Planning Application Ref: FG/174/17/PL

Location: 32 & 34a Sea Lane, Ferring

Description of works: Demolition of existing dwelling at 32 and erection of 4 new dwellings on the plot with amended access arrangements.

Comments On Application:

DRAWING TITLE
Proposed Site Plan, Location Plan
and elevation from south

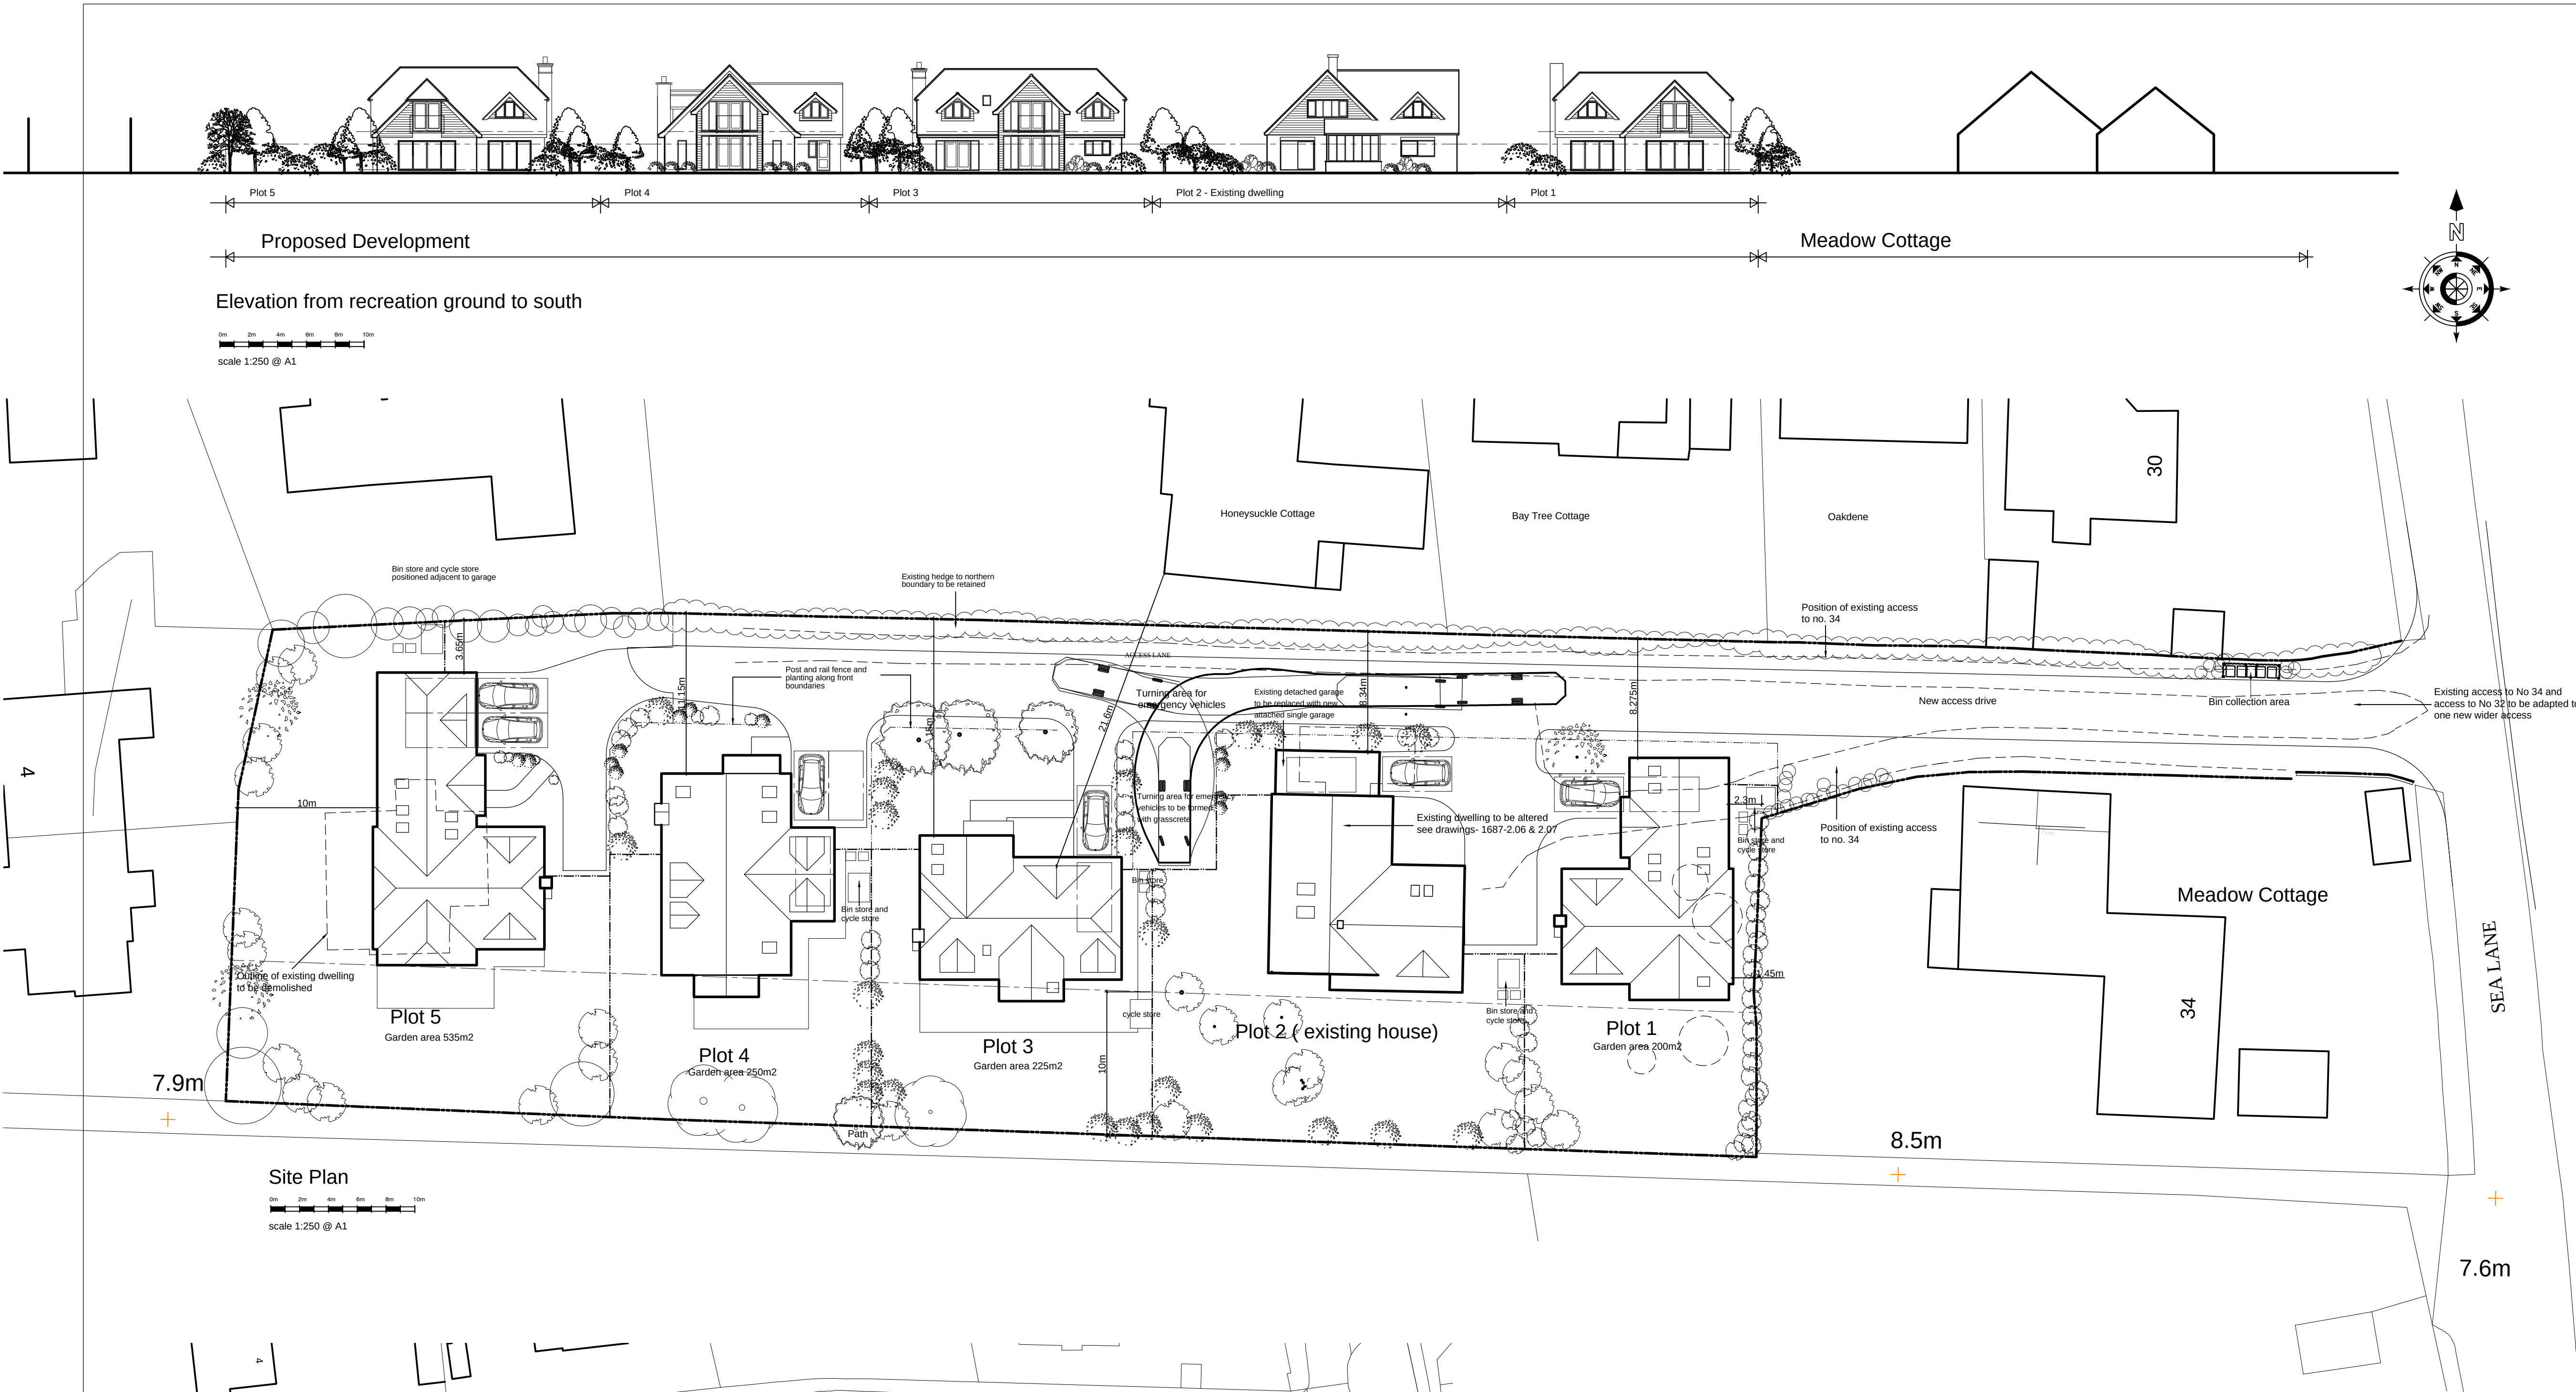
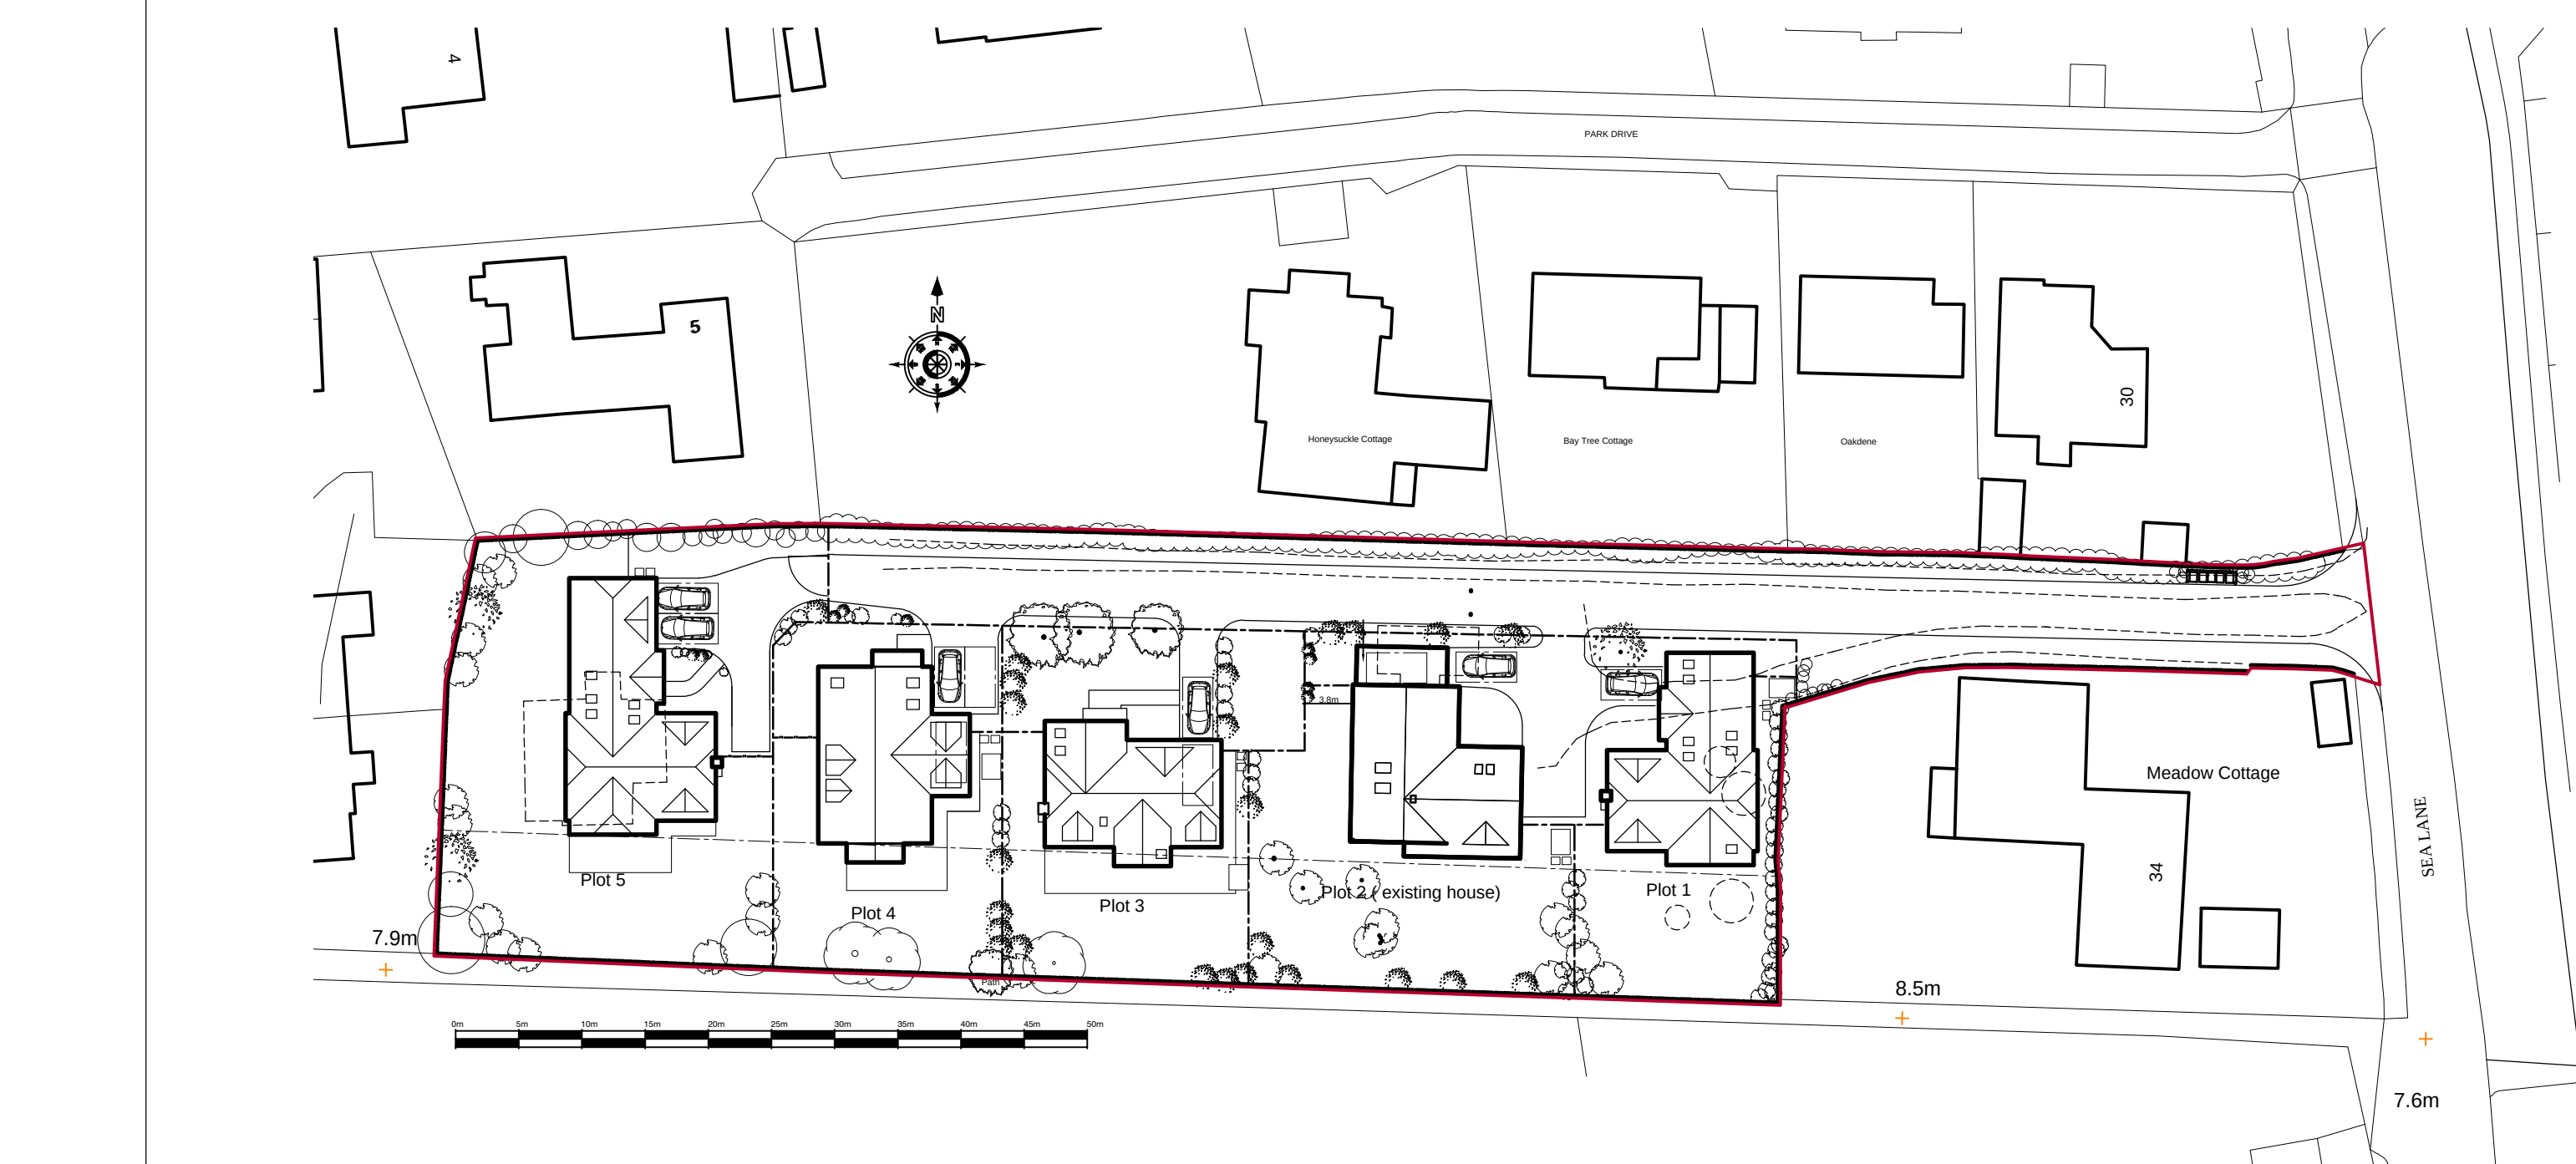
- My primary concern is for the trees in the front garden of No 34a whose RPA's will overlap the adjacent driveway access which is proposed for upgrading to merge the two existing narrow drives.

- The existing drives are in situ and as such tree roots are protected but as soon as you lift them and start to apply a new wider drive then BS5837 requires that full Arb details are submitted and a report from an Arb Expert is submitted i.e. an Arboricultural Method Statement to explain how this work will be achieved without damaging the tree roots.
